STATUTORY PLANNING CONSULTATION RESPONSE

Application Number:	3/2026/0356
Proposal:	Erection of 77 no dwellings and creation of community parkland, with vehicular access from Whalley Road and associated infrastructure, parking and landscaping.
Location:	Land at Hammond Ground Whalley Road Read BB12 7RP

The Lead Local Flood Authority **objects** to the above application on the basis of:

Objection 01 – Inadequate Surface Water Sustainable Drainage Strategy

PROPOSED DRAINAGE STRATEGY (1:500)

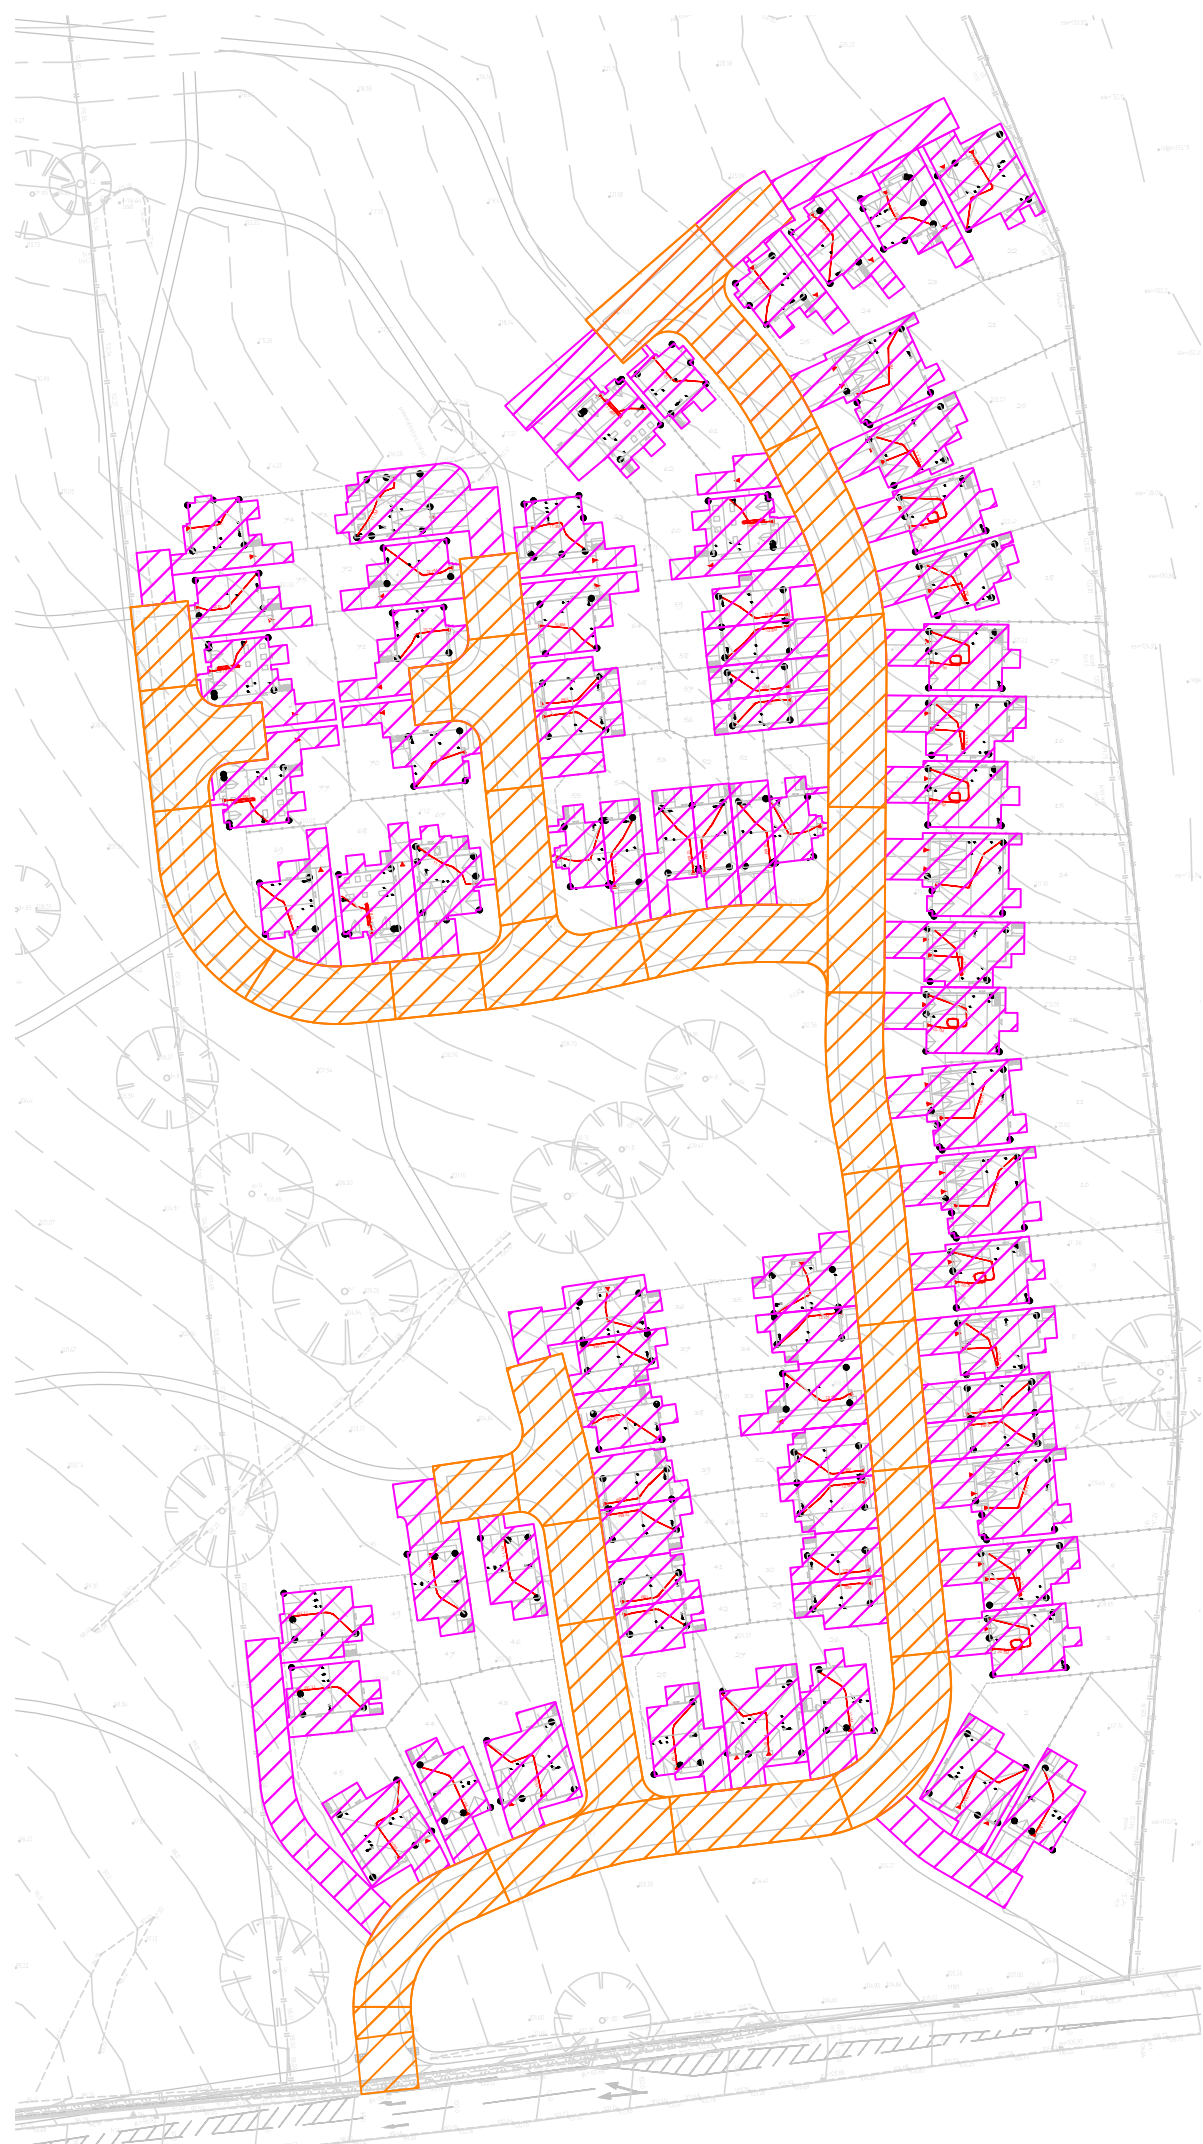
In this case, although a drainage strategy has been submitted, it is considered inadequate. It does not satisfy the requirements of the National Standards for Sustainable Drainage Systems for the following reasons:

1. **Inadequate Runoff Destination** – The proposed drainage strategy fails to demonstrate compliance with the priority hierarchy of runoff destinations set out in Standard 1 (Runoff Destinations) of the National Standards for Sustainable Drainage Systems. This Standard requires applicants to demonstrate that surface water runoff from new developments will be discharged according to a priority hierarchy, and for all higher priority destinations to be utilised to the maximum extent practicable.

In this case, the applicant proposes to discharge surface water runoff from this development to watercourse. However, sufficient evidence has not been provided to demonstrate that all higher priority final destinations have been utilised to the

maximum extent practicable. This includes non-potable use, as defined by the standard.

Further evidence is therefore required to demonstrate compliance with Standard 1 of the National Standards for Sustainable Drainage Systems.

2. **Failure to Manage Everyday Rainfall** – The proposed drainage strategy fails to demonstrate that the proposed development provides adequate measures to manage runoff from everyday rainfall events, as required by Standard 2 (Management of Everyday Rainfall (Interception)) of the National Standards for Sustainable Systems. This Standard requires a 'SuDS approach' to be applied so that at least the first 5mm of rainfall for the majority of rainfall events does not result in runoff from the site to surface waters or piped drainage systems.

Further evidence is therefore required to demonstrate compliance with Standard 2 of the National Standards for Sustainable Drainage Systems.

This should include evidence that runoff from each positively drained surface, for at least the first 5mm of rainfall, is either collected for use, infiltrated into the ground, or else captured, conveyed and stored within SuDS features. These features shall naturally absorb or retain runoff and from these the runoff will be 'lost' to soils or the atmosphere and will not discharge off the site, as required by Section 2.6.

- The applicant is expected to provide some indication as to how surface water from higher land is intended to be managed as this has the potential to have an impact on the proposed drainage and its contributing area or affect the flood risk of the post development scenario.
- The applicant is expected to provide evidence of how the proposed discharge rate has been derived based on appropriate industry standards.

You can overcome this objection by submitting a surface water sustainable drainage strategy that addresses the deficiencies identified above and demonstrates how surface water will be managed within the development in accordance with:
